Prestons Industrial Warehouse and Distribution Centre (SSD 7155)

Thank you for your recent letter requesting Transport for NSW (TfNSW) comment on the subject proposal at Prestons.

TfNSW has reviewed the documentation submitted in support of the proposals and transport related matters that require further consideration are detailed at **TAB A** and outlined below:

**SWEPT PATH ANALYSIS
OF A 25m ARTICULATED
VEHICLE ENTERING AND
EXITING THE SITE**

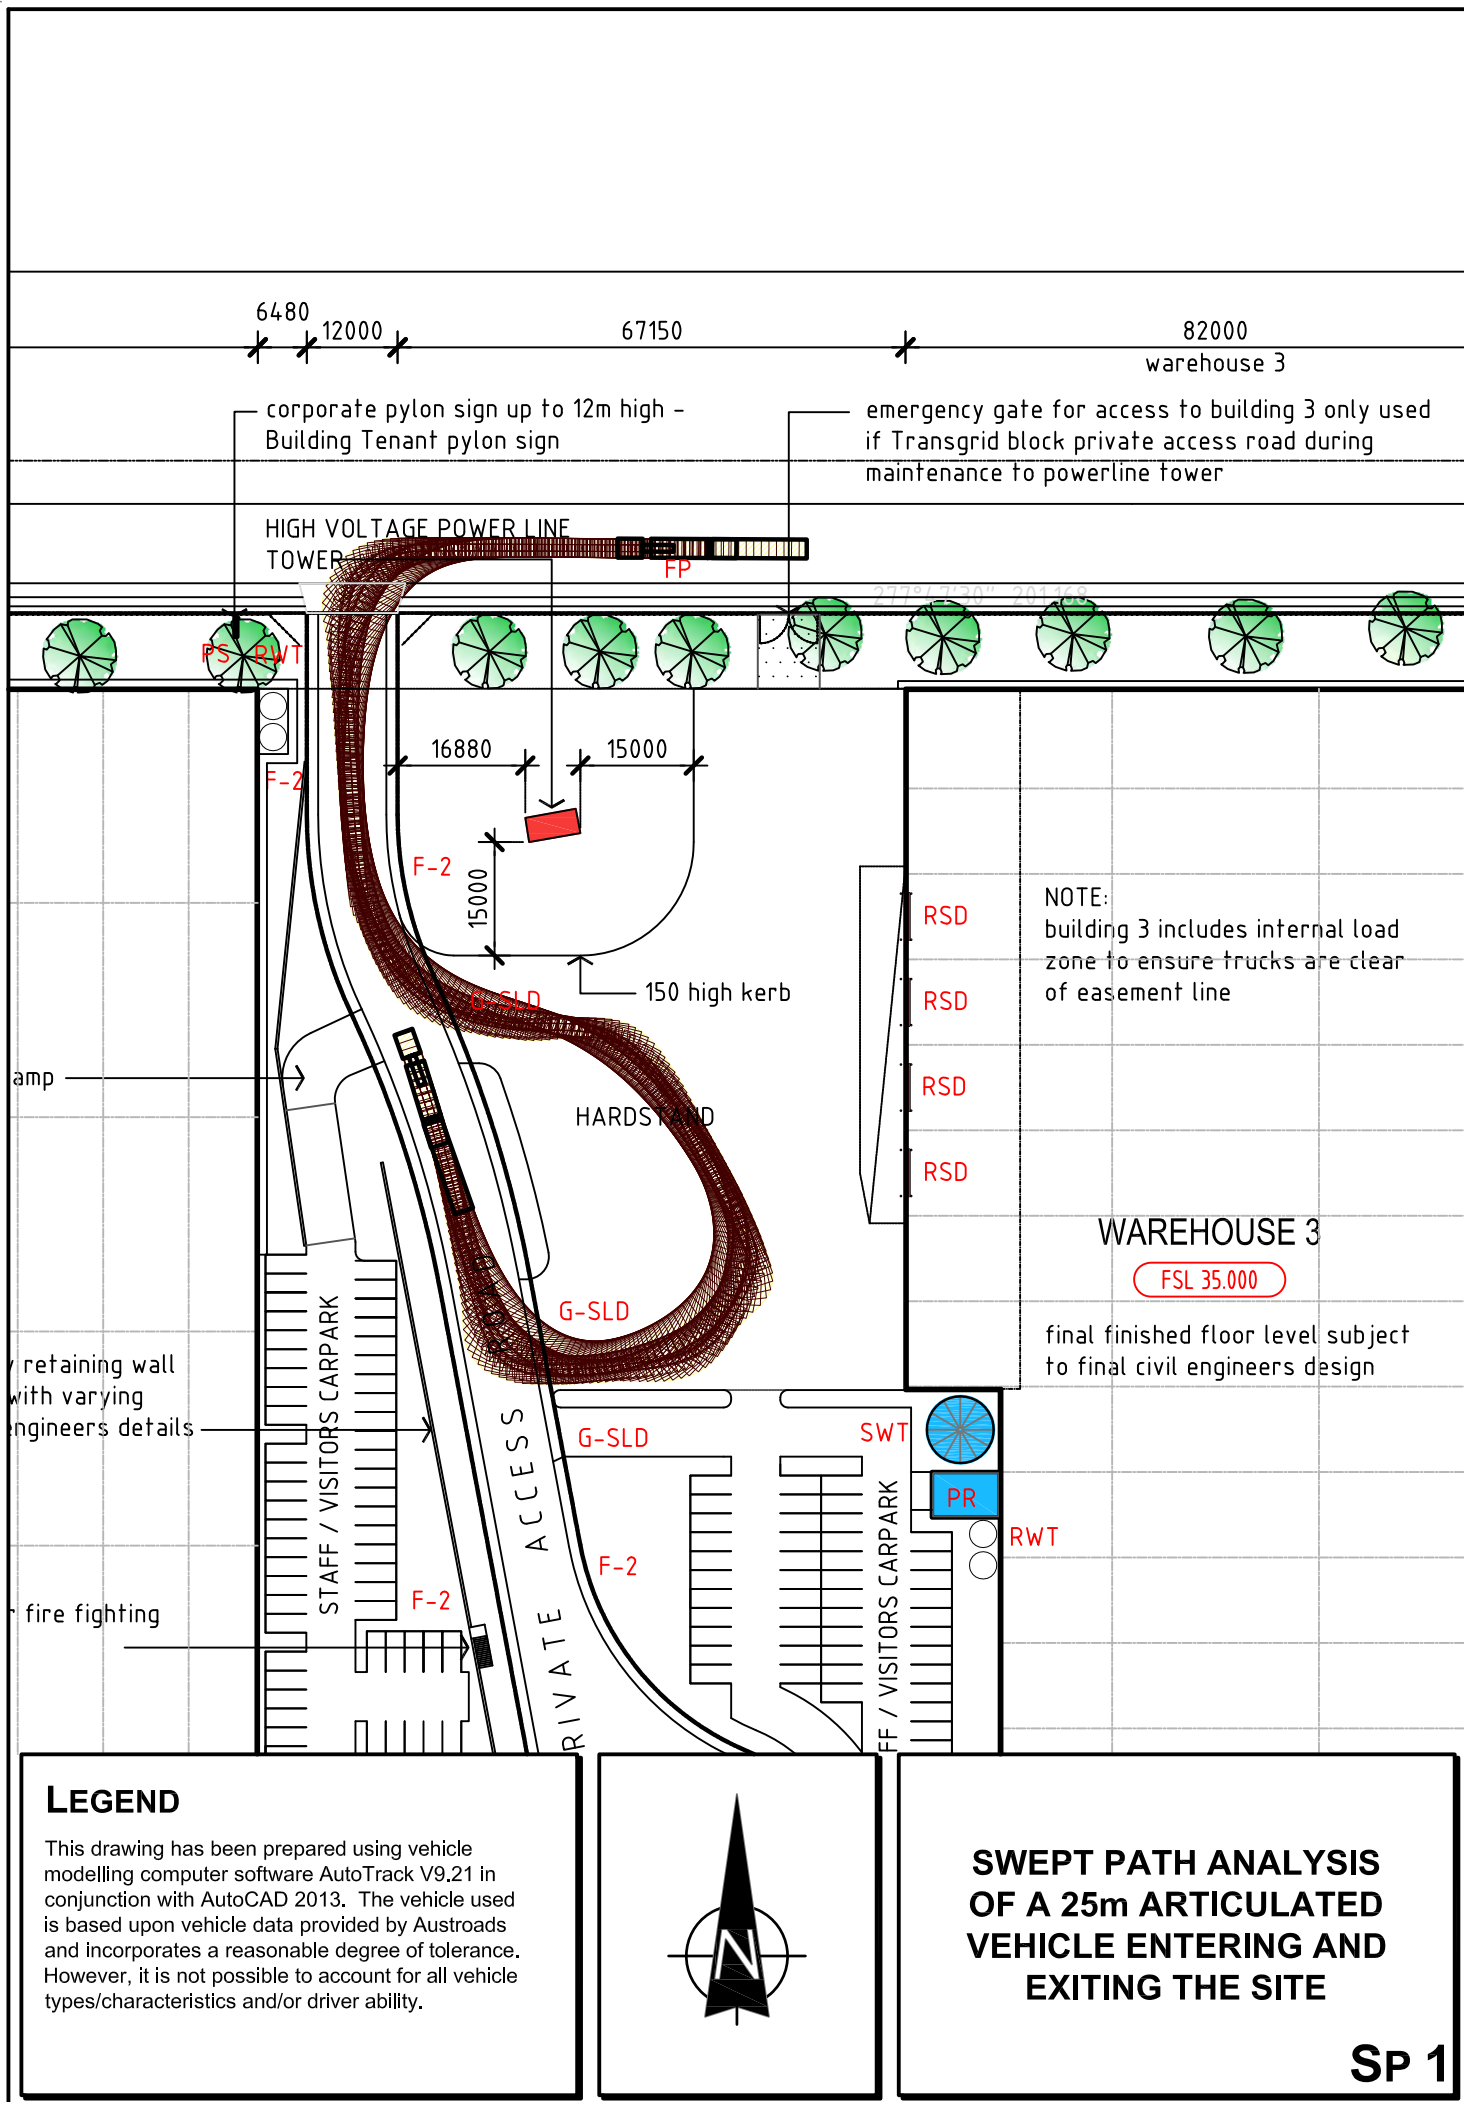
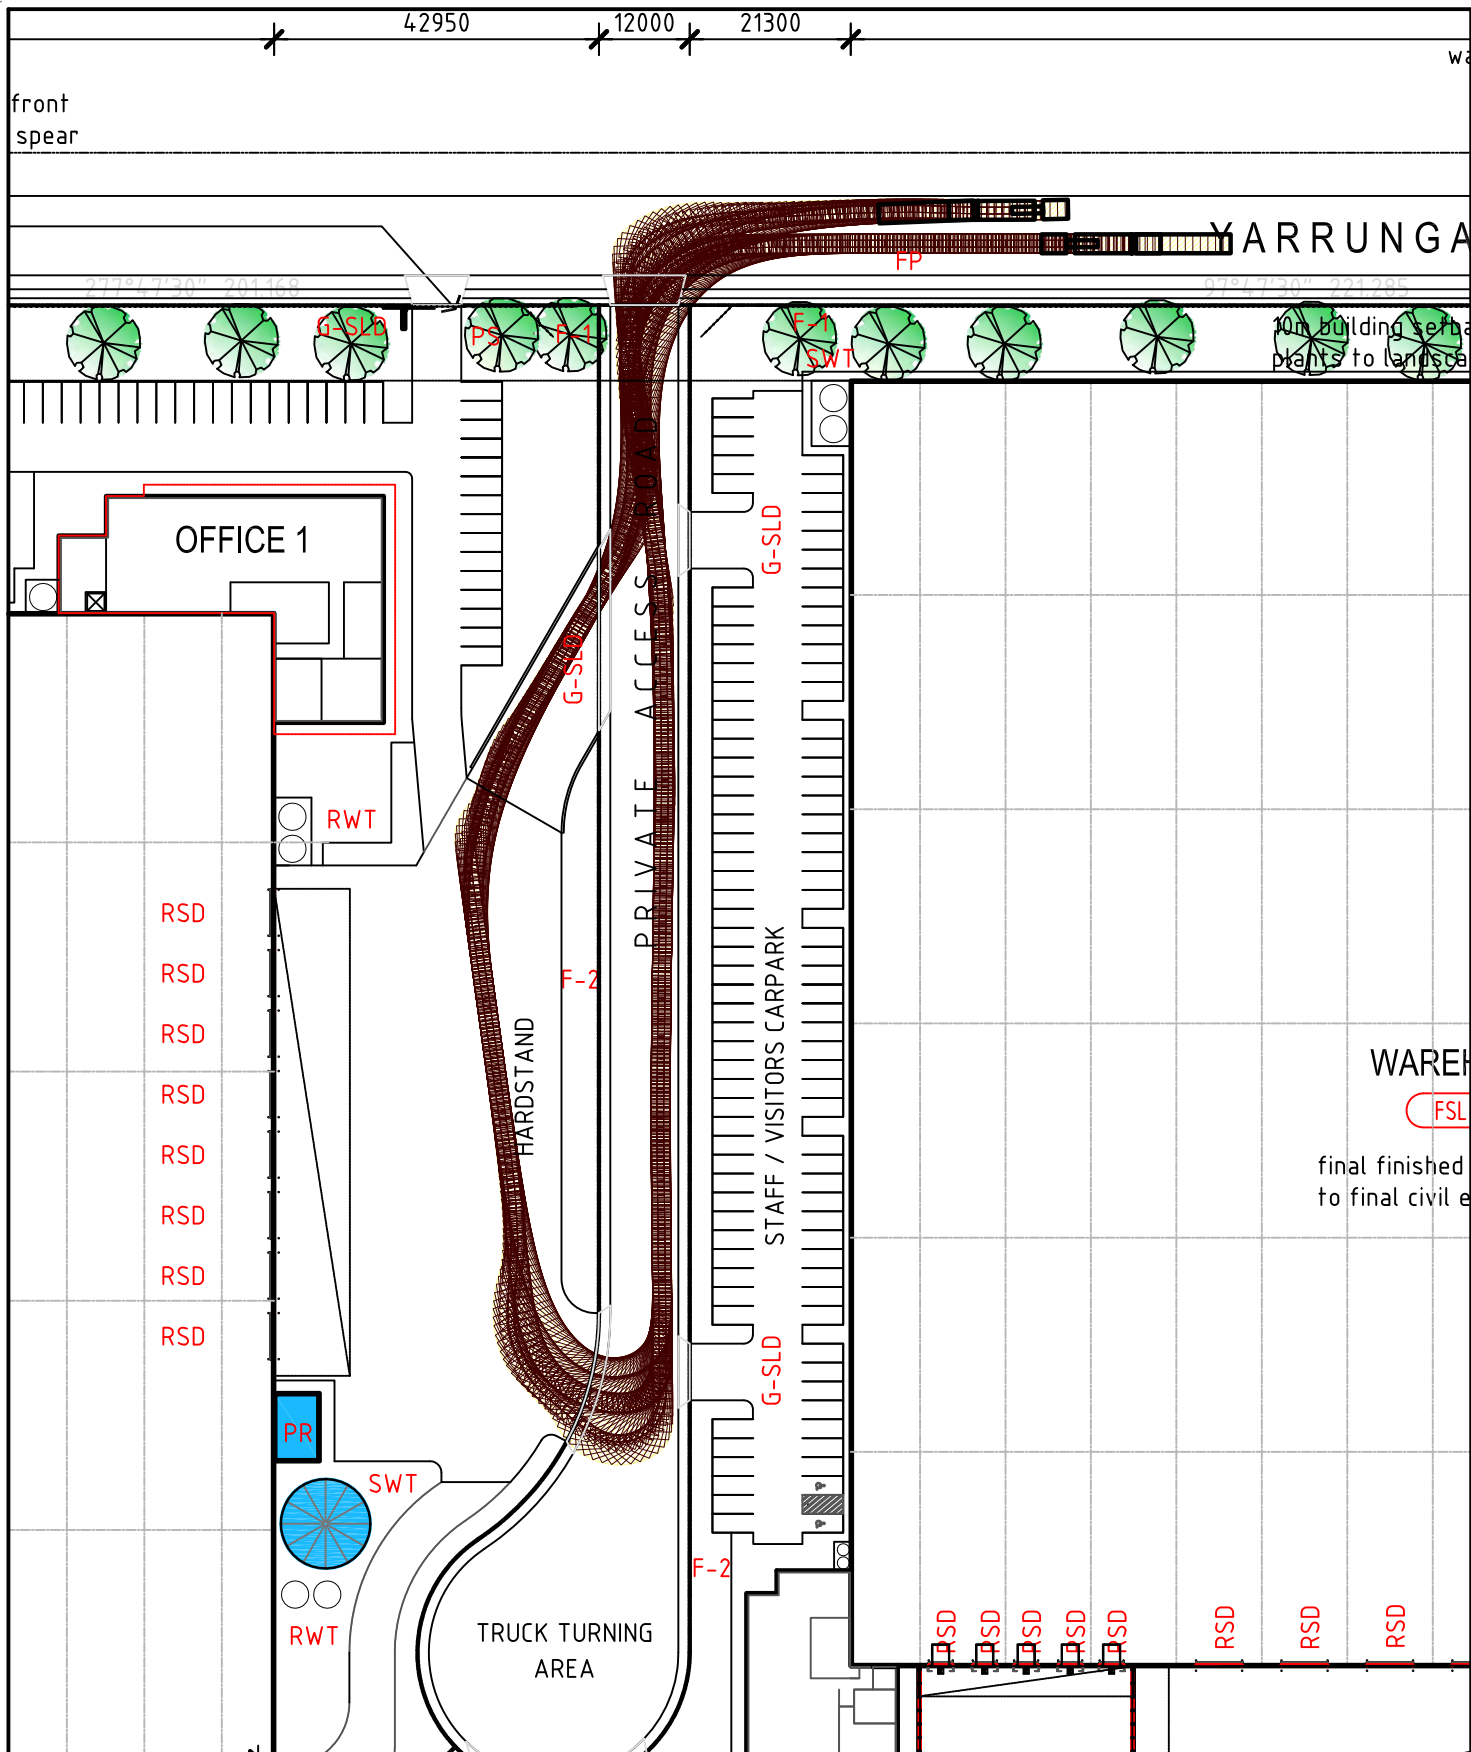
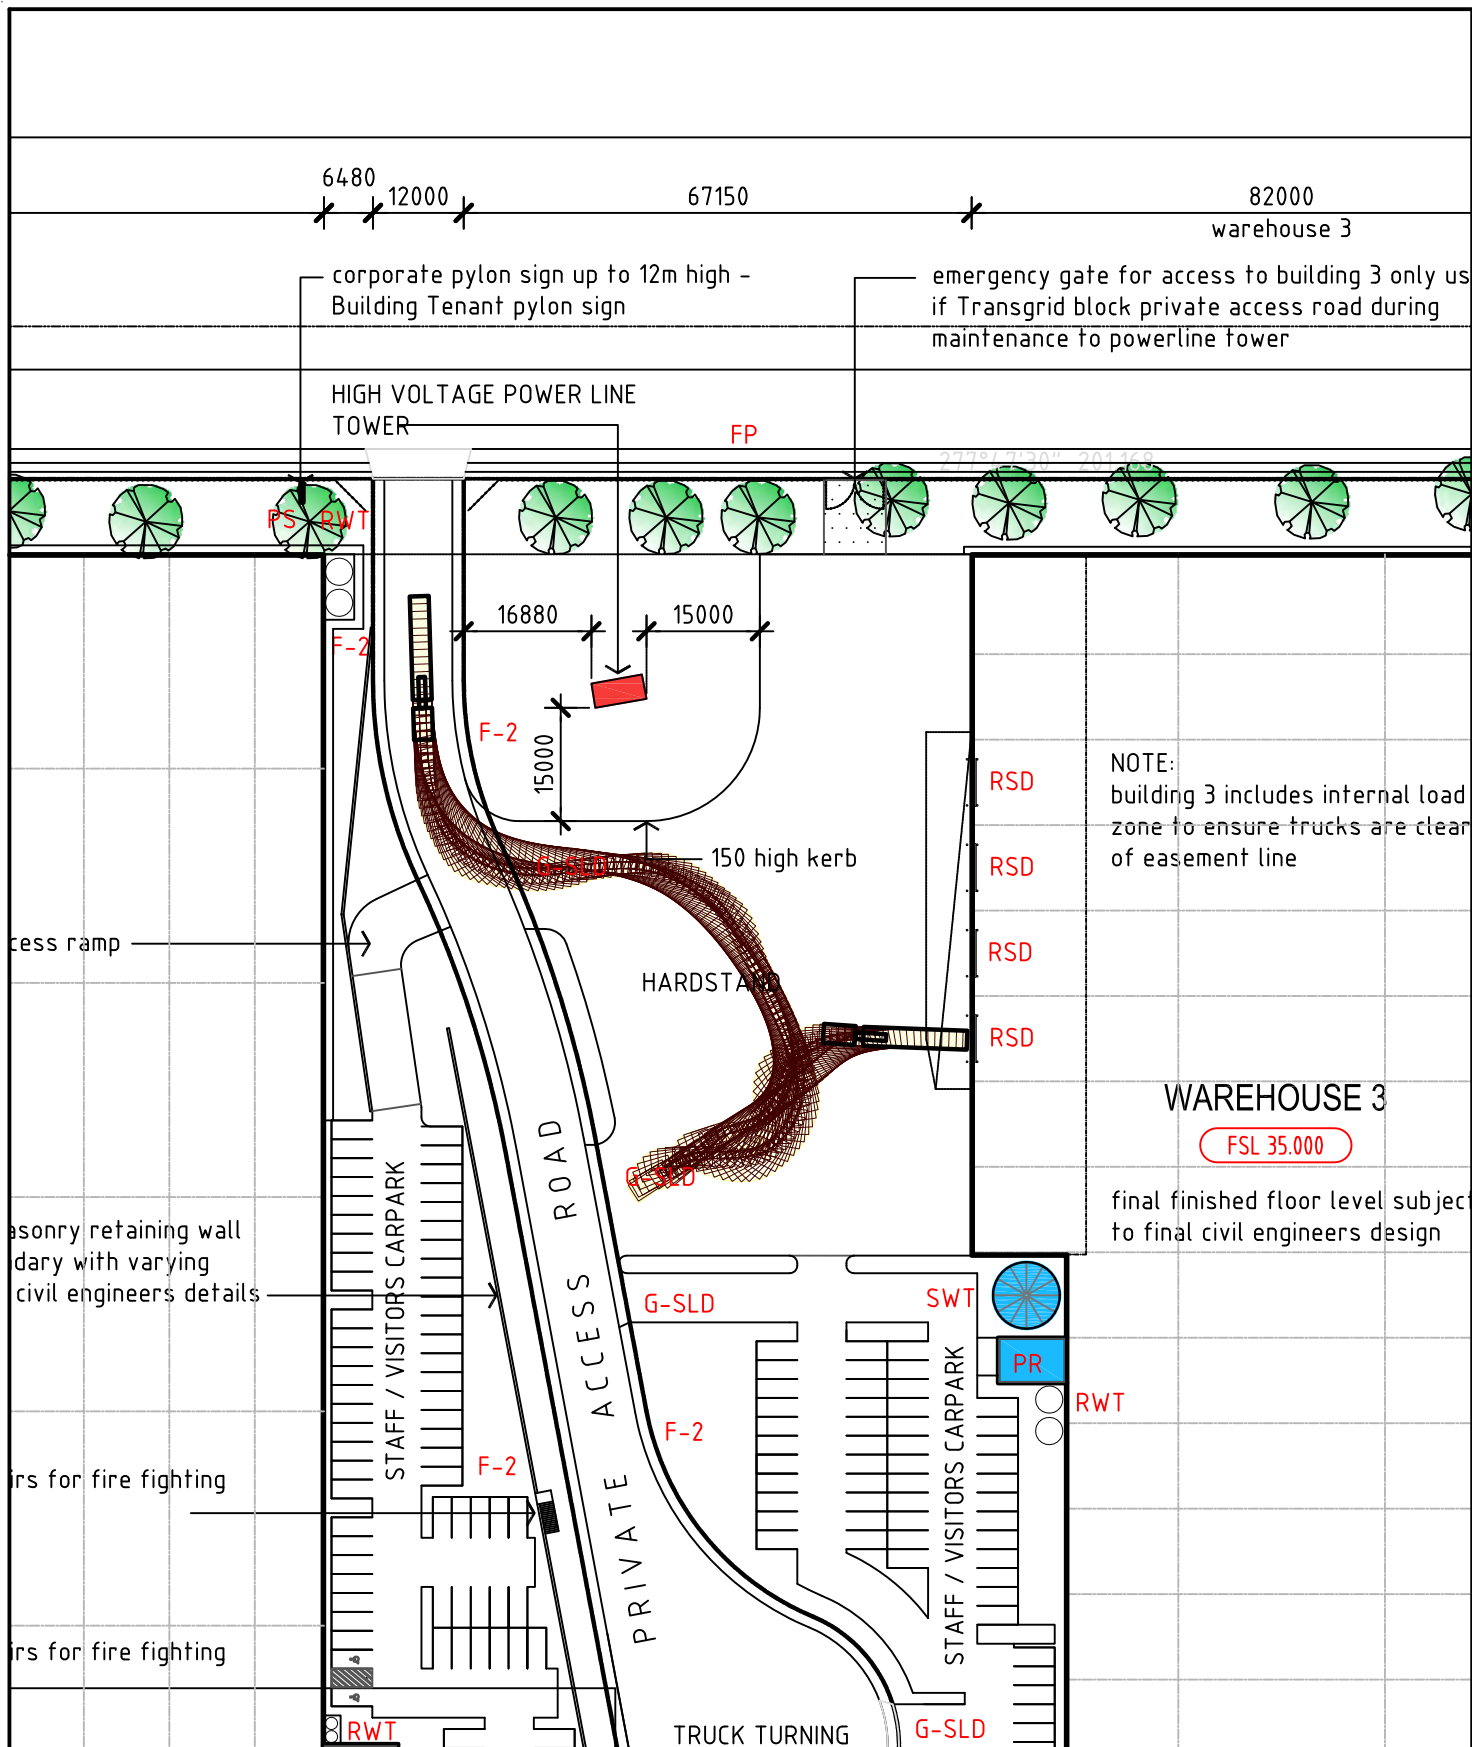
As outlined in TfNSW comments attached to the Secretary's Environmental Assessment Requirements (SEARs) it was suggested that consideration should be given to PBS 2B vehicle as the largest likely to access the site. However swept path analysis was undertaken based on 25m B-Doubles and 19m Semi-trailers for Warehouse 1, 2, 3 & 5. Swept path analysis was not provided for Warehouse 4 and the Bernera Road access driveways. It is also noted that, no details have been provided regarding locations where longer vehicles will be able to de-couple on site before manoeuvring into the docks.

It is suggested that further information including additional swept path analyses should be provided with consideration for larger design vehicles including PBS 2B. Swept path analysis should also be provided for the Bernera Road access driveways. Appropriate conditions should be considered in the conditions of consent to restrict the size of vehicles that can access the site and from the various driveways.

Consideration should also be given to appropriate decoupling locations on-site.
